From: AMIN Ahsanul
To: [DPE CSE Information Planning Mailbox](#)
Cc: [Michelle Niles](#); [Alex Wang](#)
Subject: RMS further response for SYD12/00976/08 - Proposed Modification for Wahroonga Adventist School - Fox Valley Road, Wahroonga - SSD 5535. Comments related with signalisation of the school access road & Fox Valley Road intersection.
Date: Thursday, 17 January 2019 3:20:25 PM
Attachments: [image001.jpg](#)
[image002.png](#)
Importance: High

I refer to your e-mail dated 14 December 2018 requesting Roads and Maritime to further consider a request from the proponent of Wahroonga Adventist School in relation to a condition to execute a WAD (works authorisation deed) with Roads and Maritime and to complete the signalisation of Fox Valley Road & school access road intersection.

DESIGN LAYOUT
WAHROONGA
TCS No. 3210

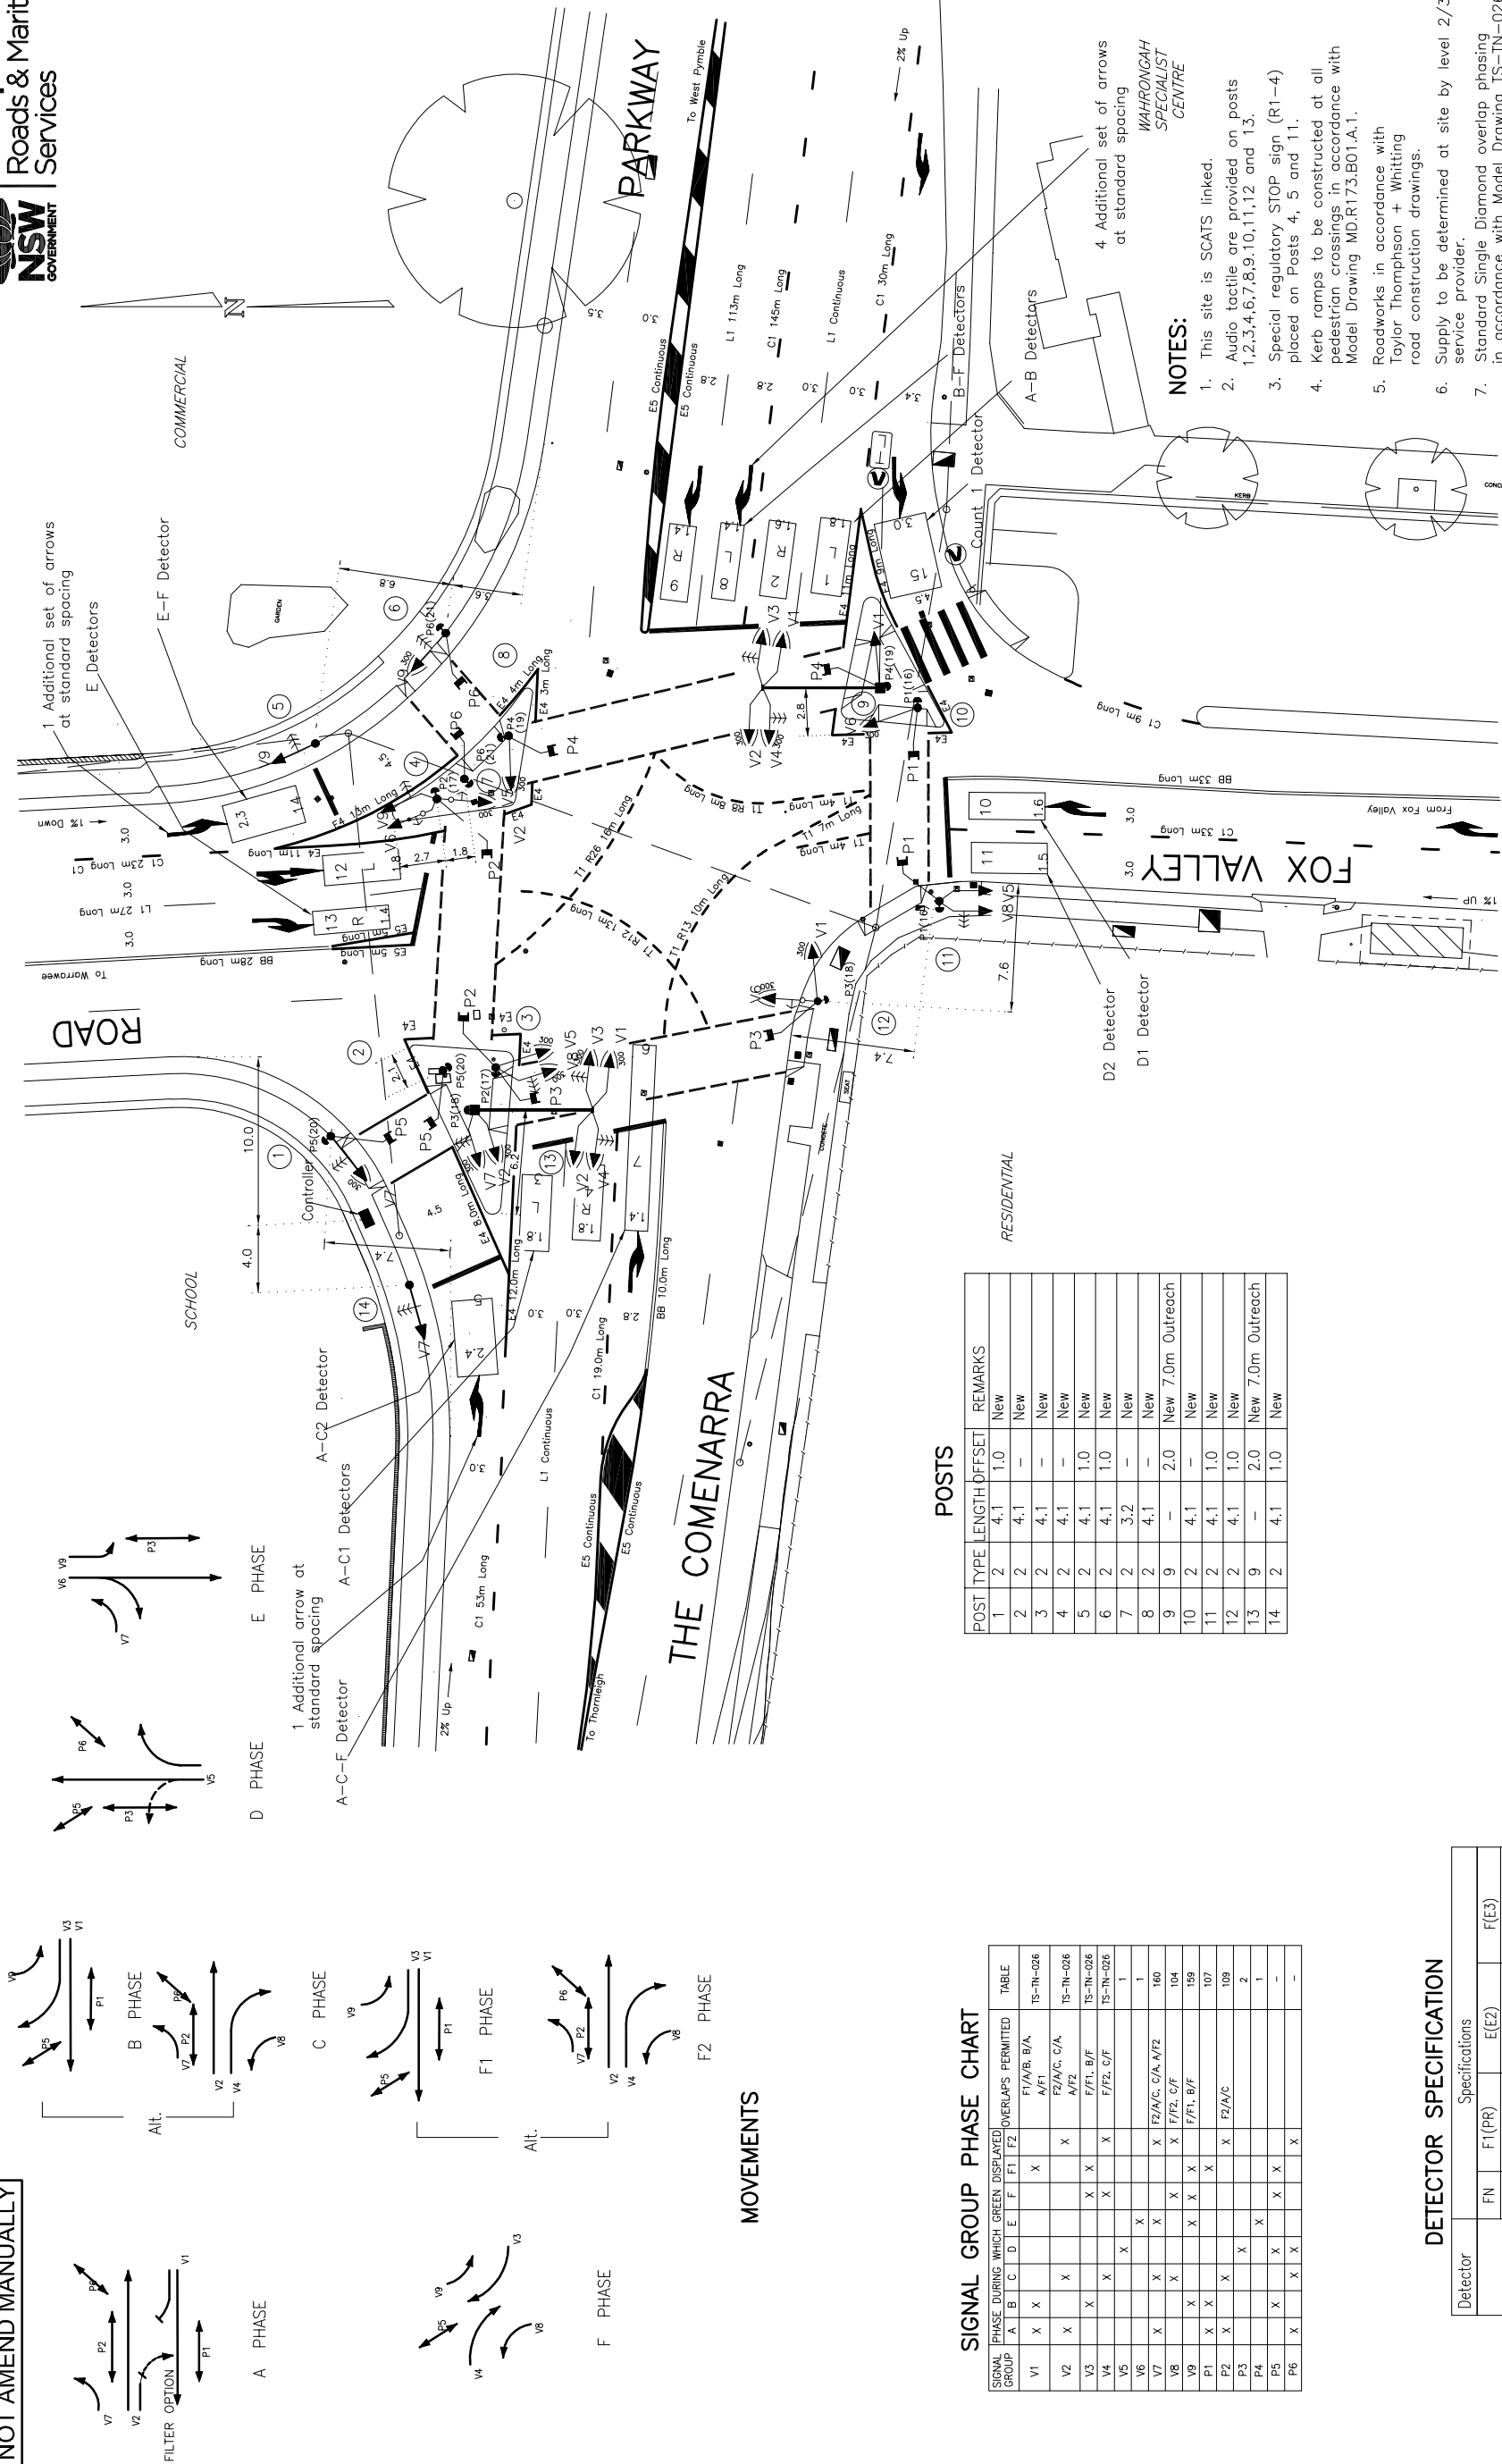
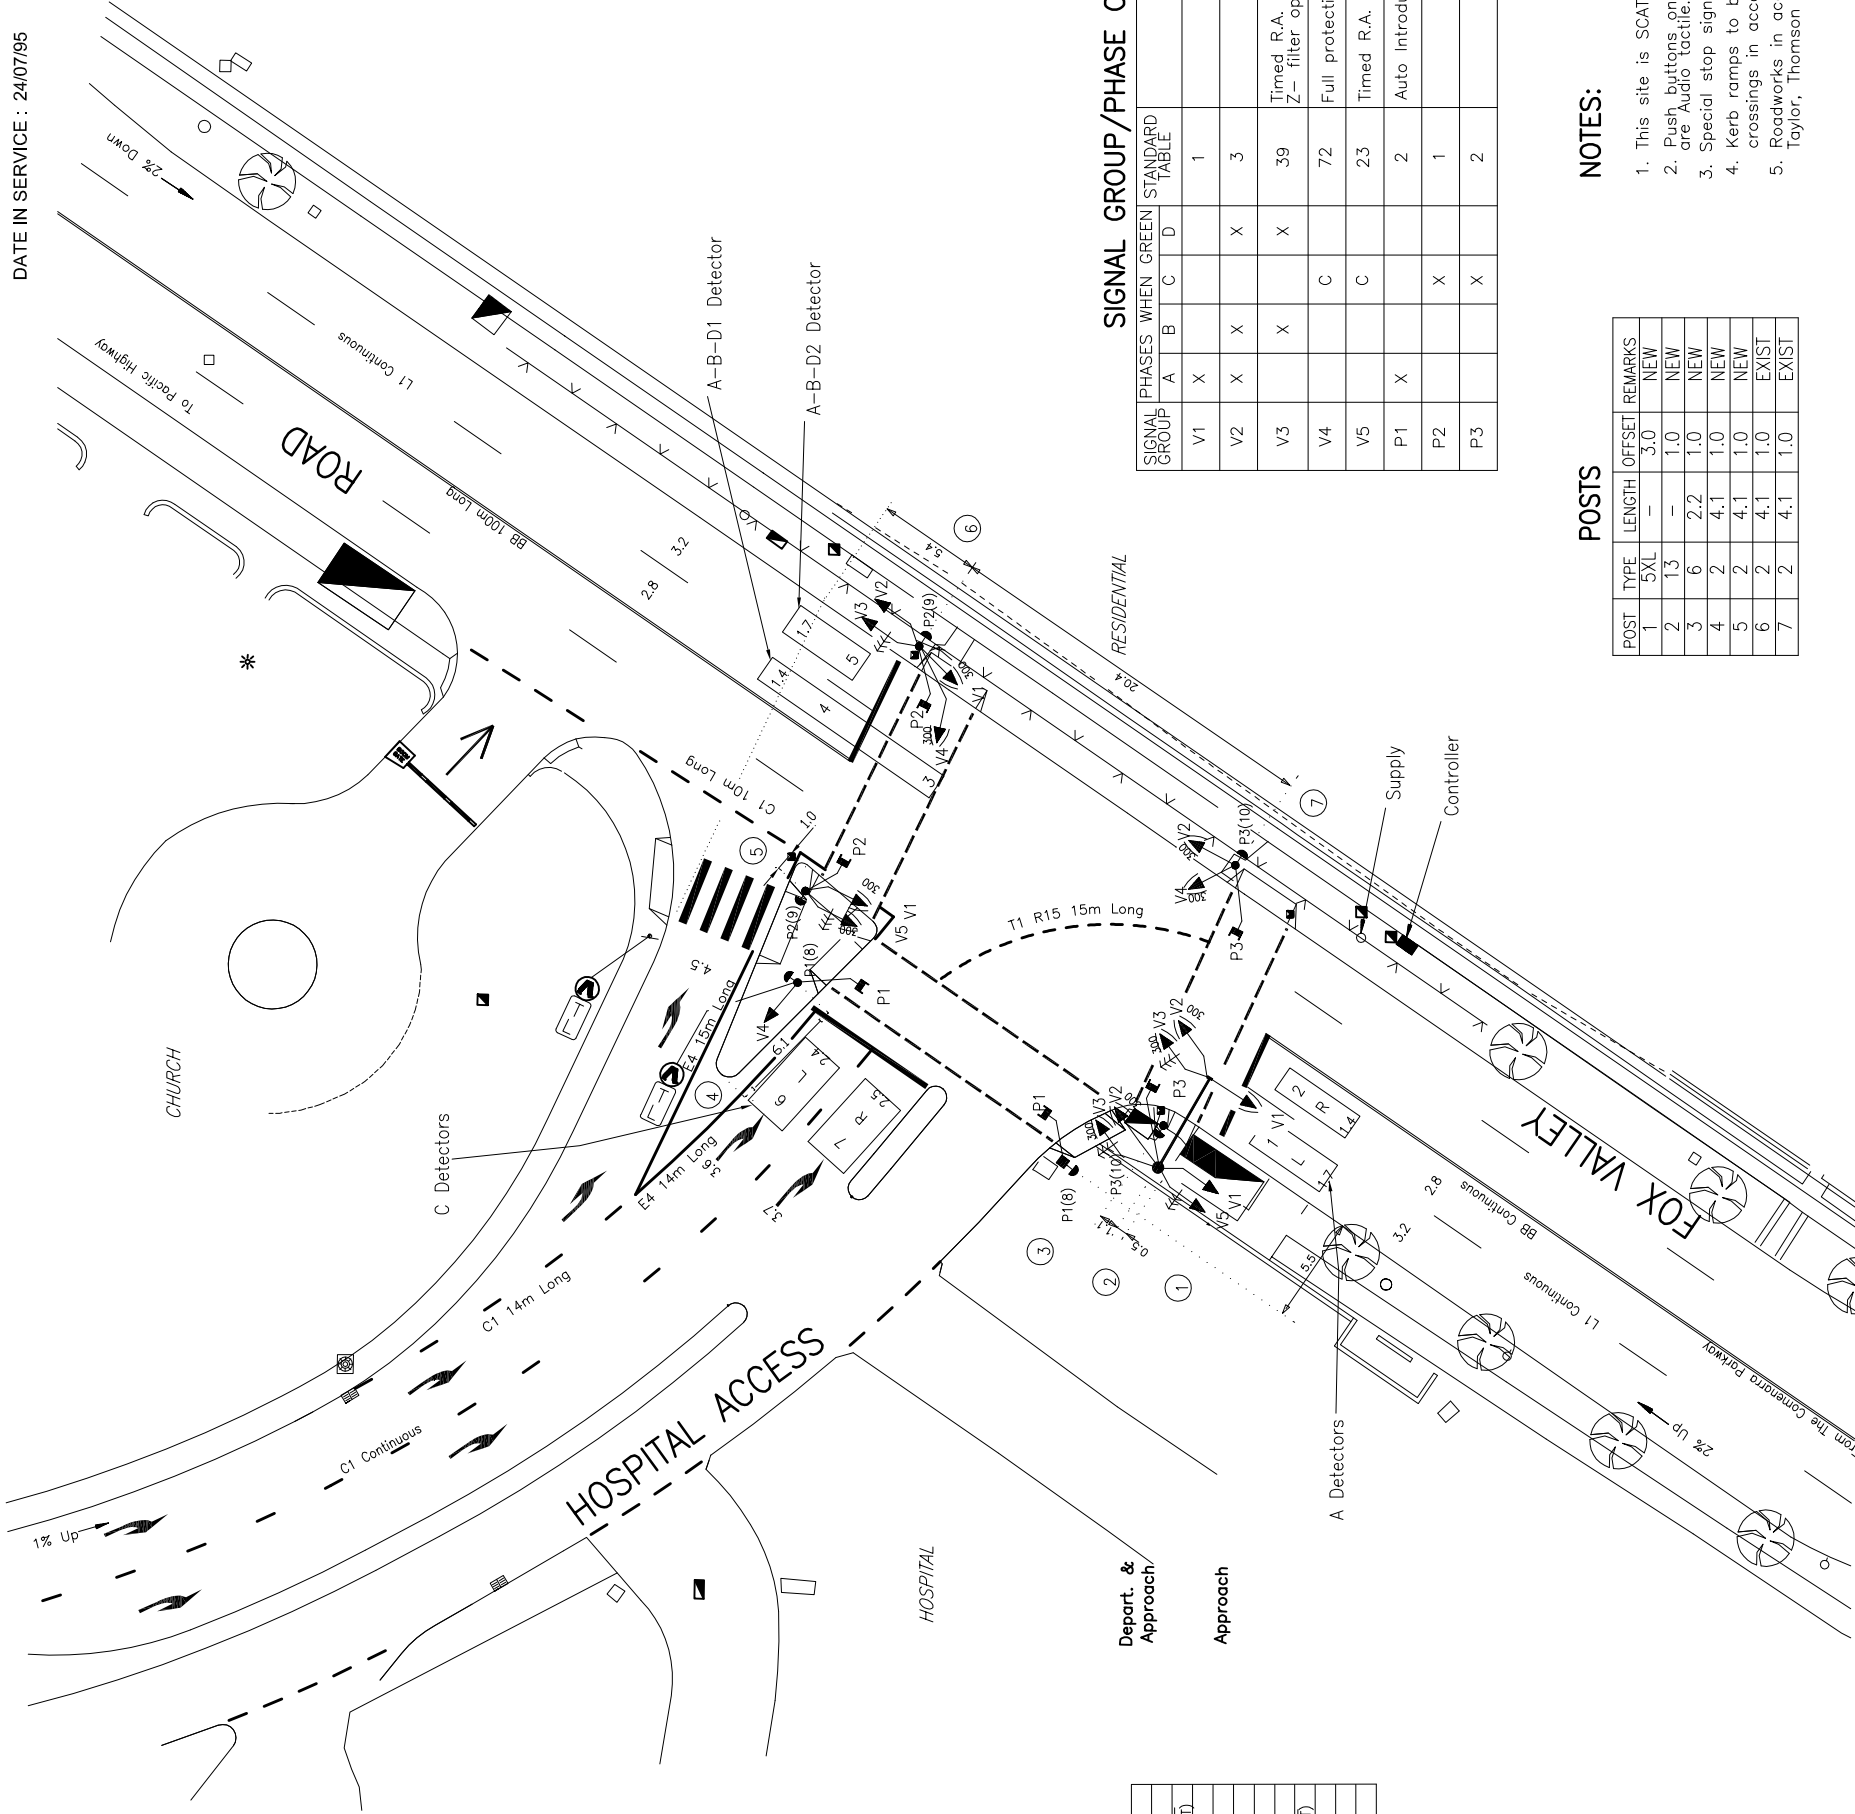
Roads and Maritime does not support the above condition as there is no timeframe attached with this condition to execute the Deed and to complete the road work. In addition, the subject traffic signal is an important element of the subject development and is require to manage the additional traffic and to provide a safe pedestrian and vehicle access to/from the site.

Based on the above, Roads and Maritime emphasise its previous comments: *"To ensure that satisfactory vehicular and pedestrian access is provided for Wahroonga Adventist School, proponent shall execute the WAD (works authorisation deed) with Roads and Maritime no later than June 2019. The signalised intersection at Fox Valley Road and new school access road shall be operational by the end of 2019."*

Please note that Roads and Maritime and Council is working closely with the proponent to finalise the intersection layout and signal design.
